Flood Risk Assessment Addendum

Planning application 21/00500/Out (Land north of Railway House Hook Norton)

This addendum responds to the consultation of the LLFA which has initially objected to the application requesting that further information be provided

soil infiltration rate, f = 3.31 x 10⁻⁵ ms⁻¹

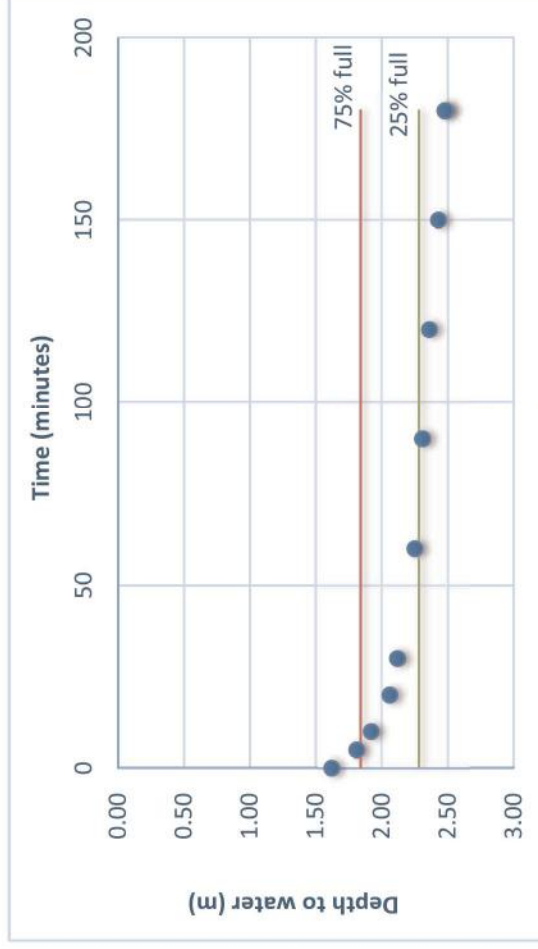
First the consultation response identifies a discrepancy in the infiltration rates used in the Micro Drainage printouts contained in the Appendices to the FRA and the text of the FRA itself.

The printouts identify an infiltration coefficient of 0.11916 m/hr, which converts to 3.31×10^{-5} m/sec. This is as identified in the main text of the report, however the consultation response refers to a rate of 3.23×10^{-5} m/s. Notwithstanding this, the difference between 3.31×10^{-5} and 3.23×10^{-5} m/s is negligible but in any event this is a “good” infiltration rate, providing an indication that infiltration is an appropriate means of disposing of surface water.

Drawing Title **Indicative Surface Water Drainage Arrangements**

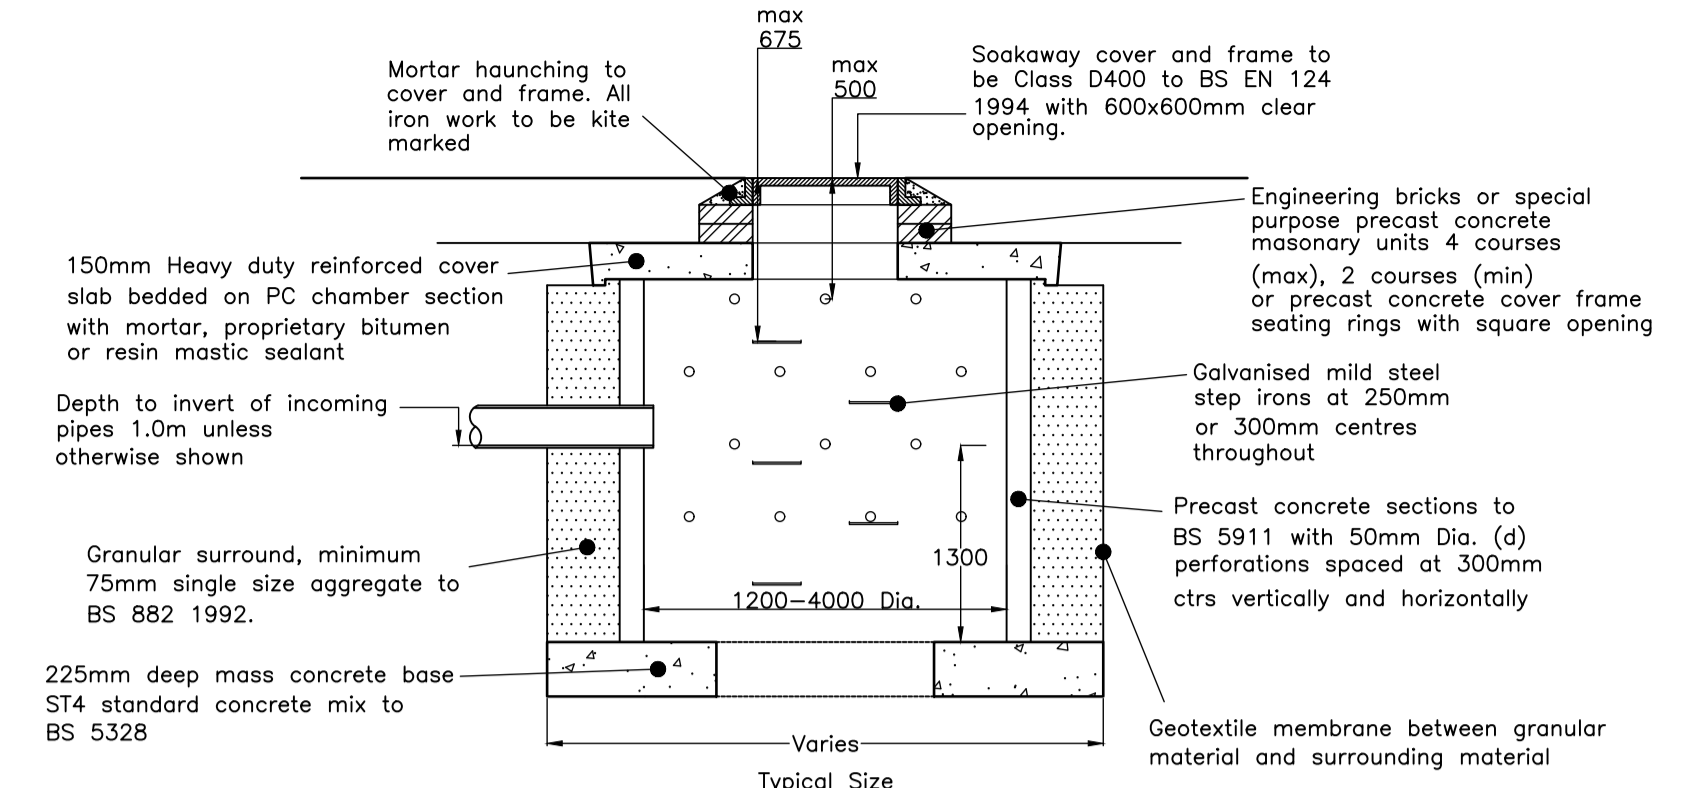
The consultation response then goes on to request further infiltration is undertaken at other locations across the site and that further information regarding “hard” and “soft” areas is provided. However, because this is an outline planning application the layout plan is illustrative only and may change when a detailed site layout is developed. Accordingly, the FRA states :

When a “Reserved Matters” layout is being prepared, further “focused” infiltration testing will be carried out to verify the design criteria for each dwelling and the hard surfaces, and accordingly, at this outline stage, a condition requiring further infiltration testing to be carried out to inform a detailed surface water drainage surface water drainage scheme to be submitted and approved by the LPA is considered an appropriate and reasonable condition to attach any planning permission.

It is therefore respectfully submitted that, to undertake further infiltration testing at other locations may, at the present time, be a relatively fruitless exercise as, when a detailed site layout is worked up, the location of any infiltration features will almost certainly vary from those shown on the illustrative plan.

Accordingly, when reserved matters are submitted, the testing can then be carried out more precisely at any proposed soakaway or infiltration feature locations.

At the same time the exact areas (hard or soft) which will drain to each infiltration feature will be established so that the each soakaway can be individually designed in accordance with the requirements of BRE 365 – hence the reason for the FRA suggesting that a condition is the most appropriate way forward for an outline planning application where layout matters are not yet fixed in stone (this approach was considered acceptable for the previous outline application and it is submitted that the same principles can apply to this application).
